AS/KS
09389
7 July 2015

DESIGN AMENDMENTS

MP09_0167 MOD4 | 45 MACQUARIE STREET, PARRAMATTA

Roof

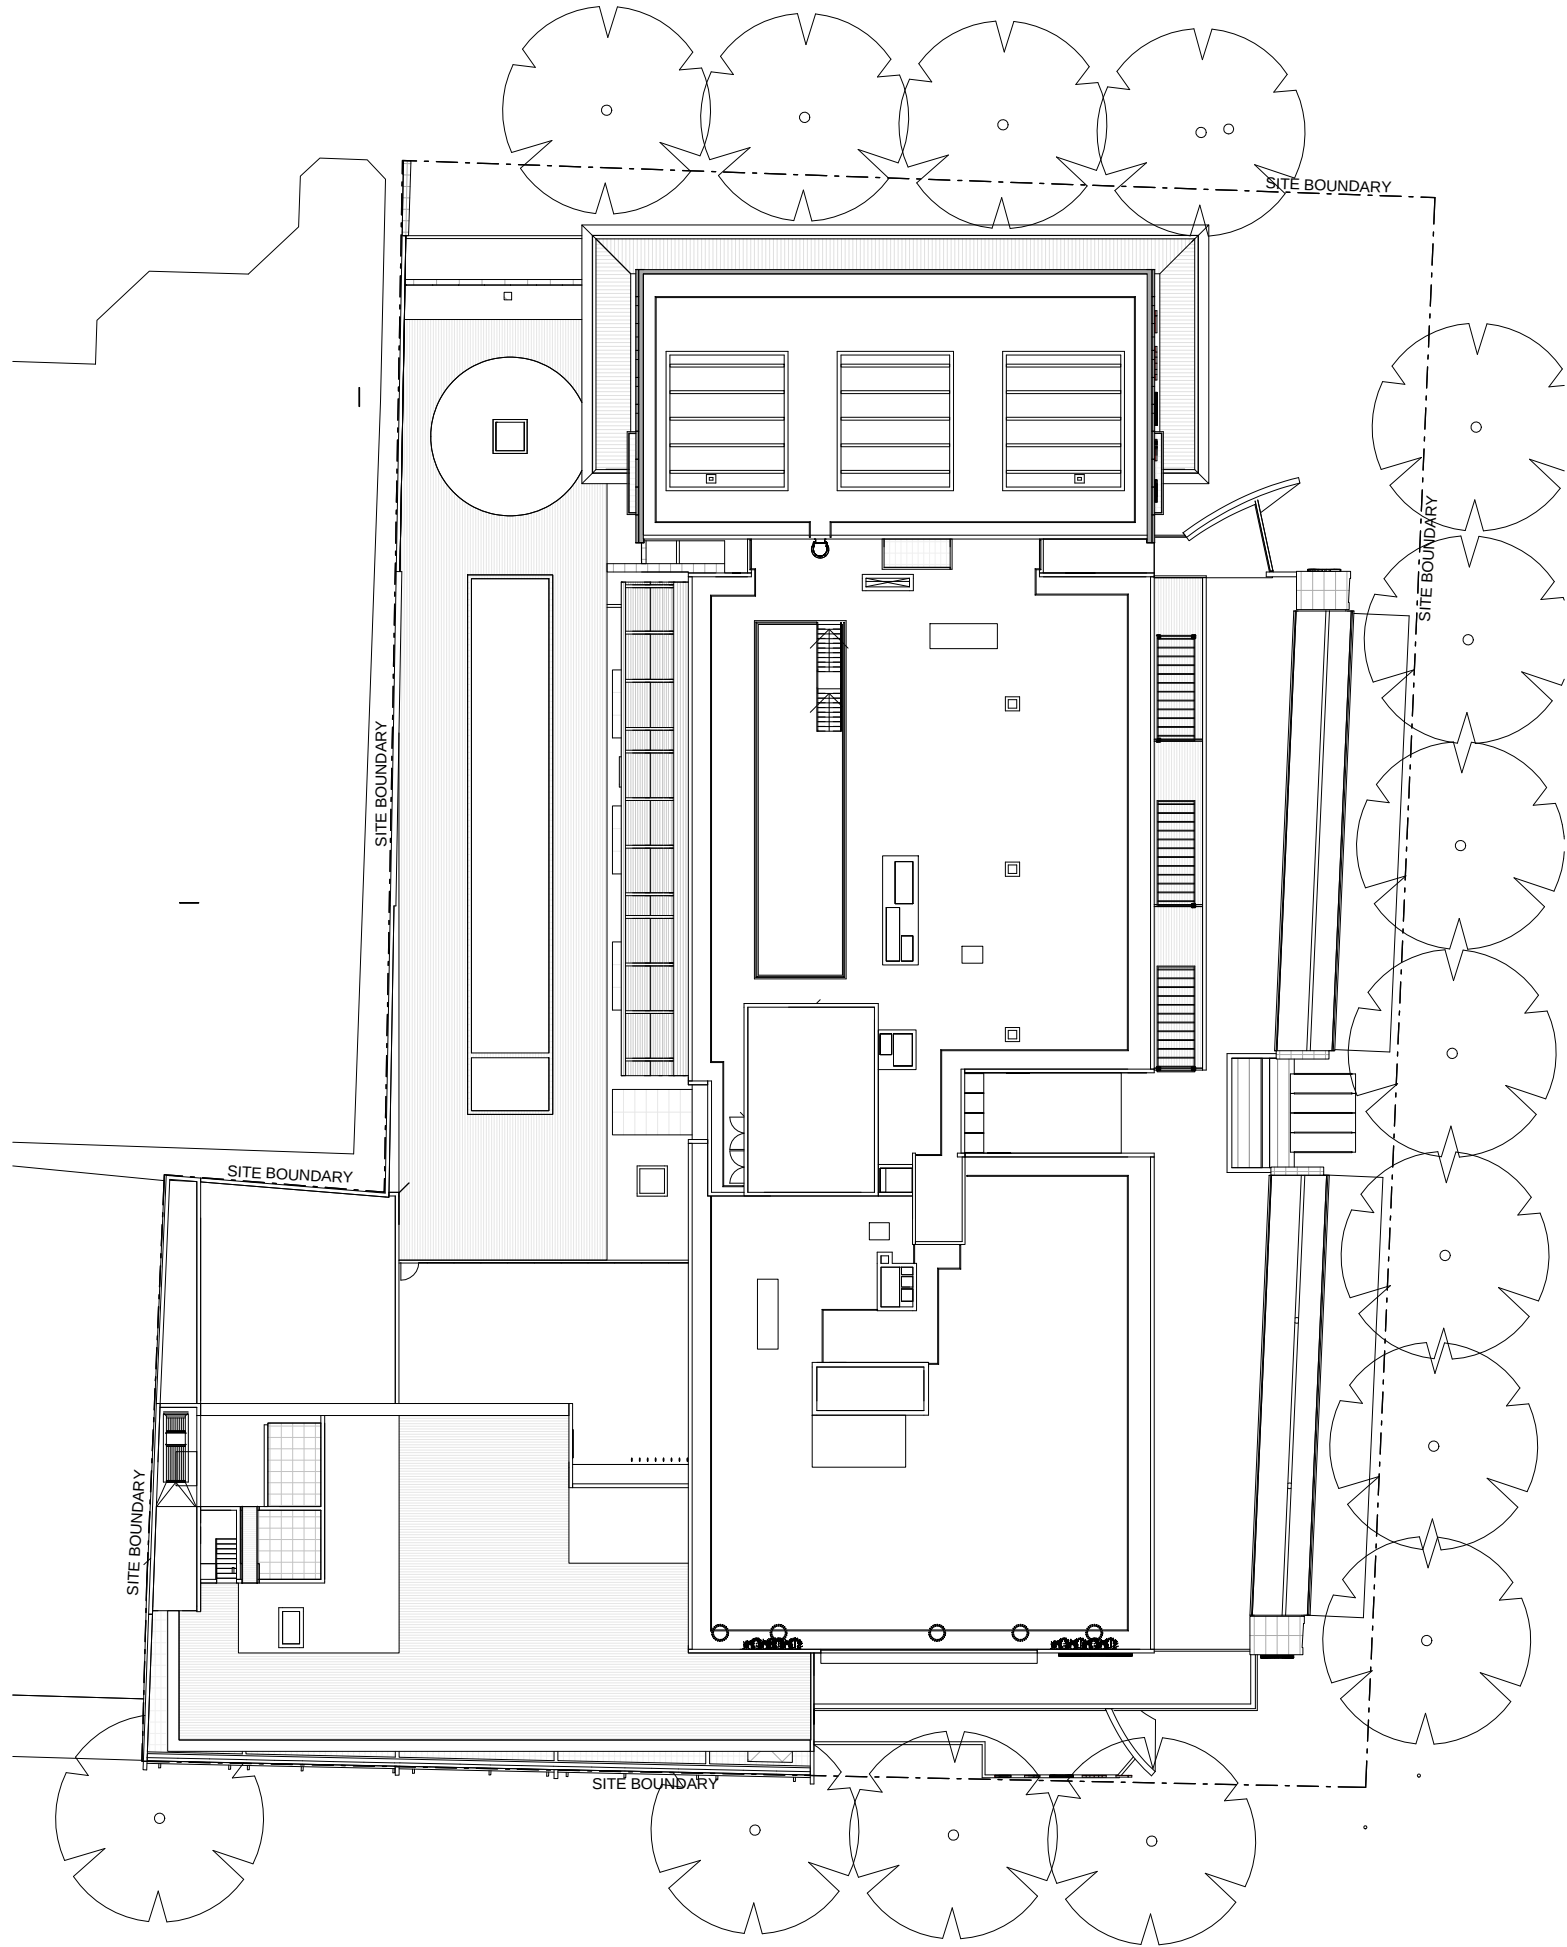
- **Deletion of lightning rods.** As part of design development, it has been determined that the lightning rods are no longer required for lightning protection and are therefore proposed to be deleted. The removal of the proposed lightning rods will also reduce the construction risk in regards to this detail, and will also reduce the impact of the building when viewed from Parramatta Park.
- **Relocation of V Lounge bathrooms from level 27 to level 26.** The toilets are now located on the same level as the remainder of the bar, in order to improve the amenity.
- **Additional balcony added to middle penthouse on level 28.** An additional balcony has been added to the middle penthouse, on the southern façade of the building. The northern penthouse balconies have also been extended on level 28. The internal layouts of the penthouses have also been improved.
